RE: Large Lot Subdivision (LL-21-00001 Bailey) Application Unable to Process

CDS has performed an initial review of your Large Lot application (LL-21-00001 Bailey). The subject parcel is split zoned between Agriculture 20 and Commercial Agriculture. Your application for a Large Lot Subdivision proposing to create 3 lots can't be processed due to the following issue:

BAILEY SHORT PLAT PART OF SECTION 15, T. 16 N., R. 20 E., W.M. KITTITAS COUNTY, WASHINGTON

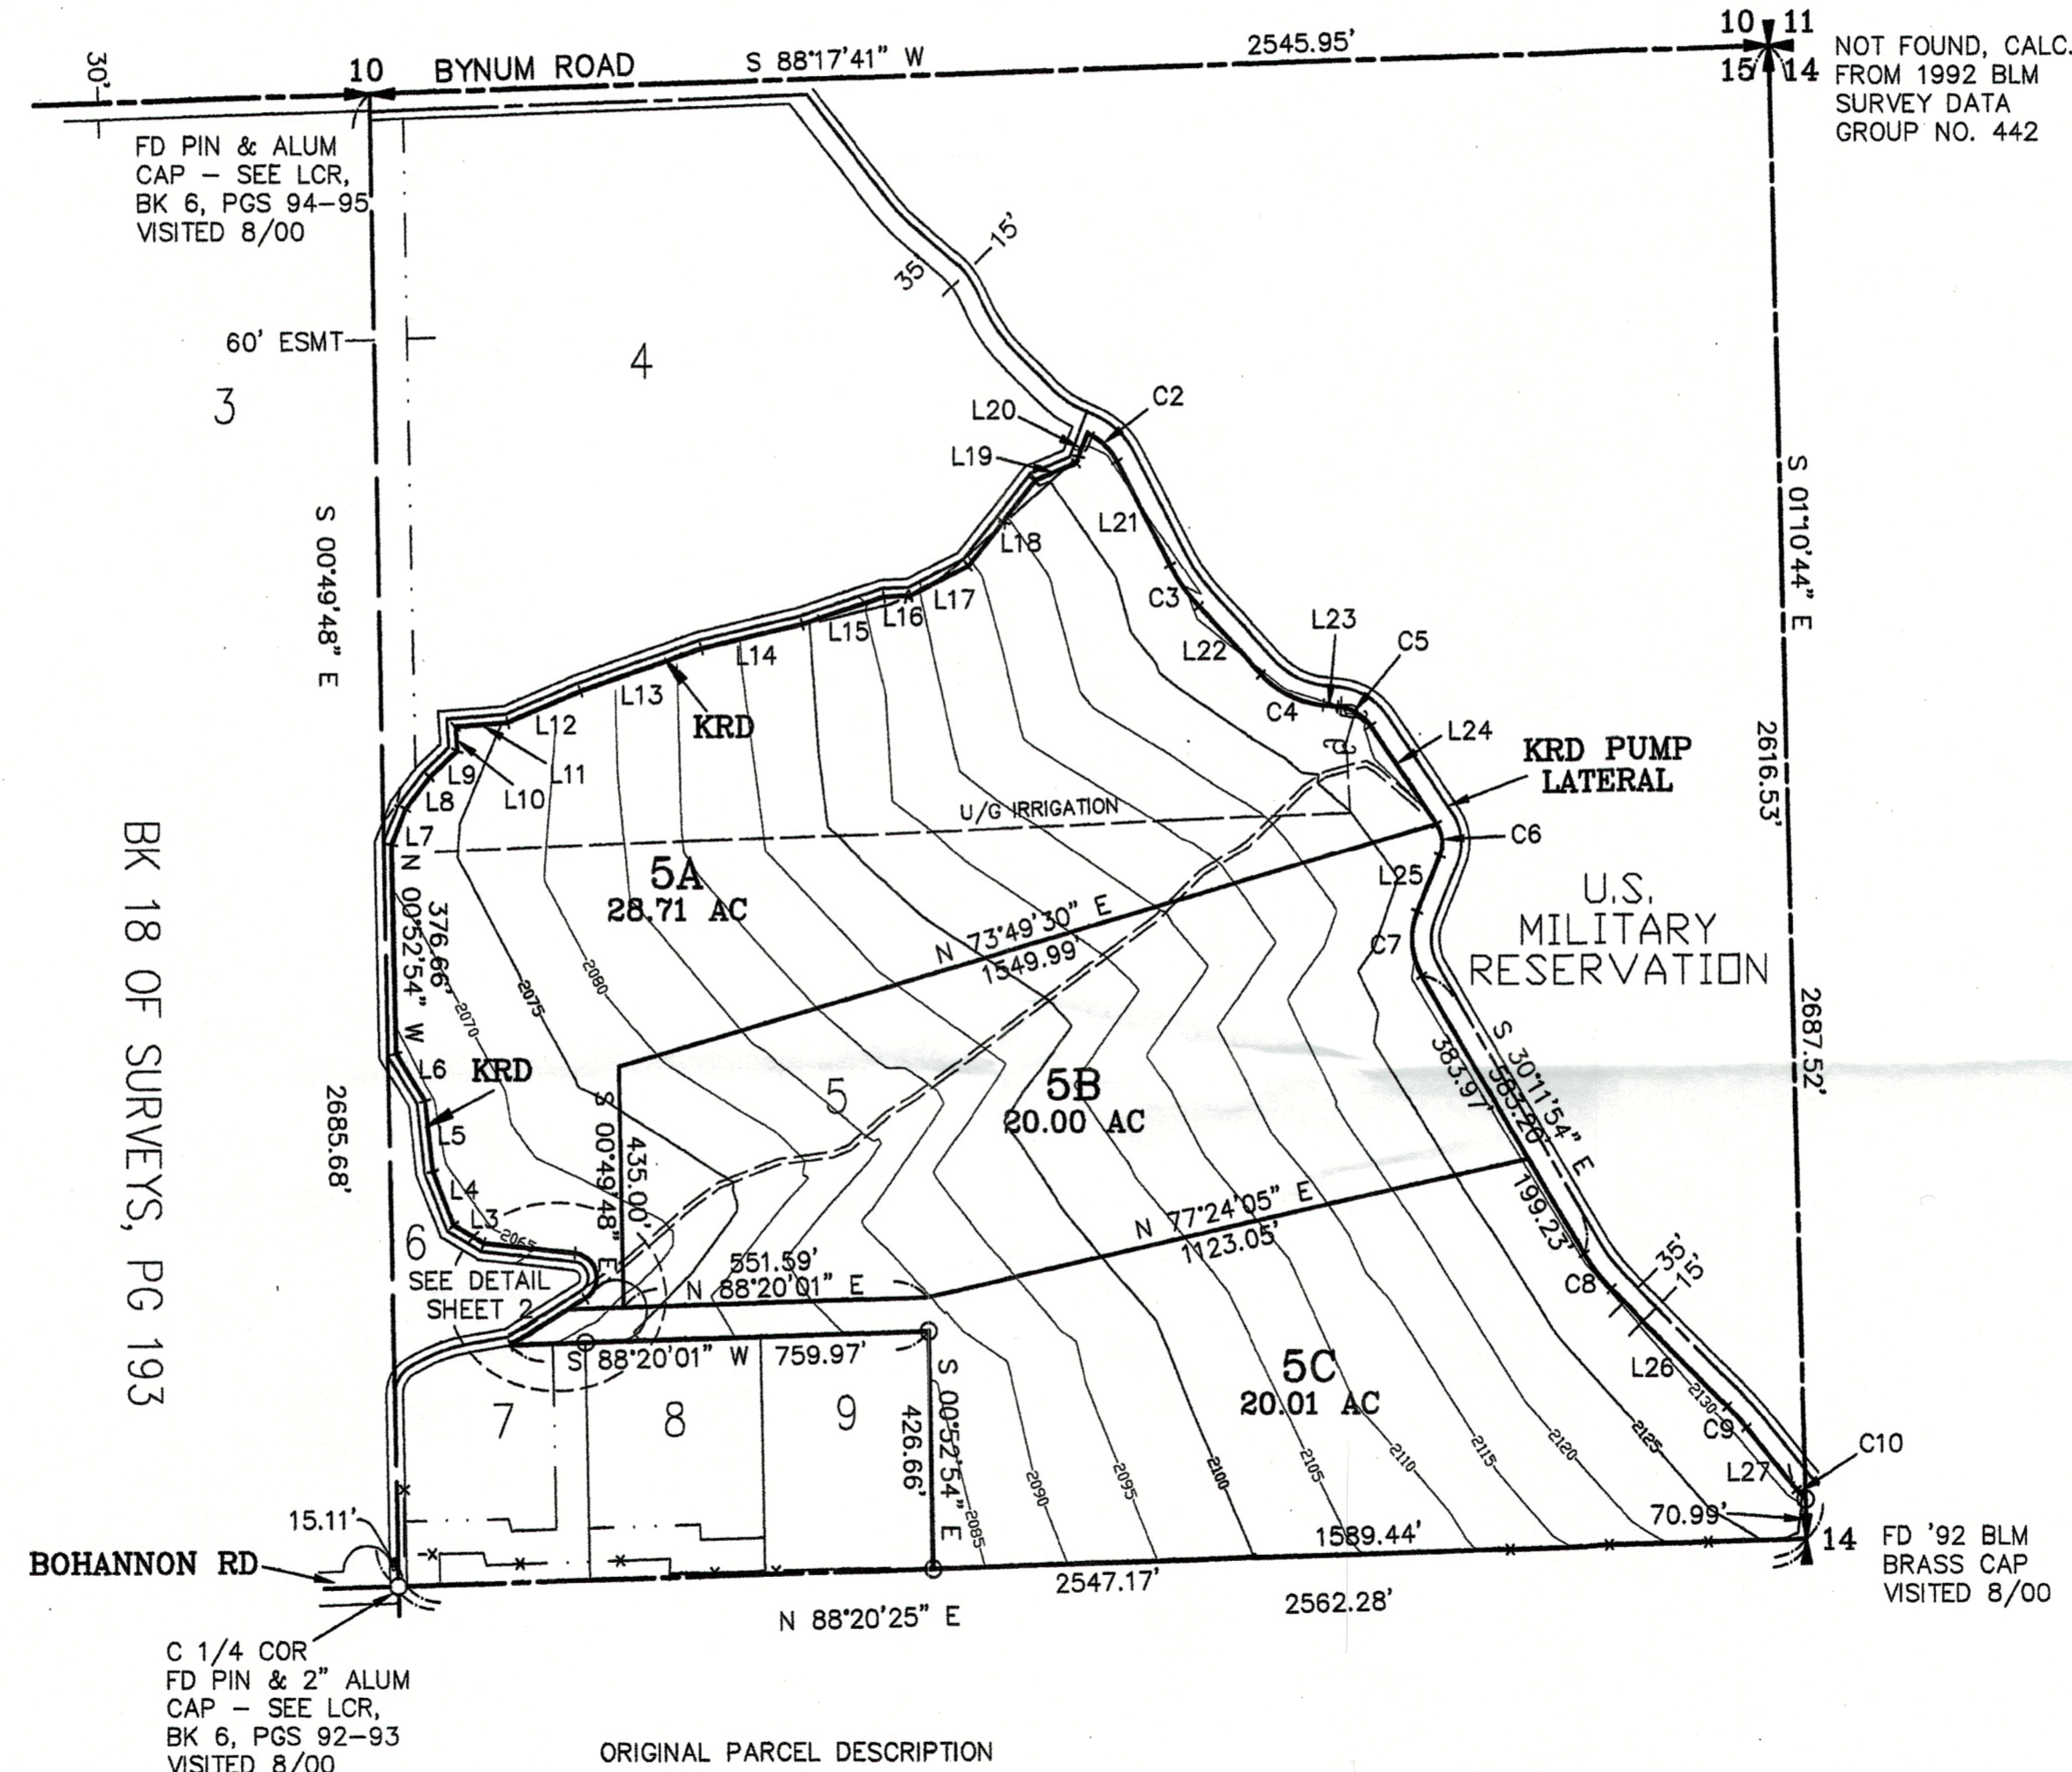
1. The parcels proposed to be platted are split zoned. According to Kittitas County Code 16.04.025: "No lot created through the provisions of this Title or adjusted through the boundary line adjustment process shall contain more than one land use zone classification."

CDS cannot approve any subdivision that results in new lots created that contain more than one zoning designation.

You can either adjust the application to resolve this conflict or withdraw the application. Please let us know how you wish to proceed.
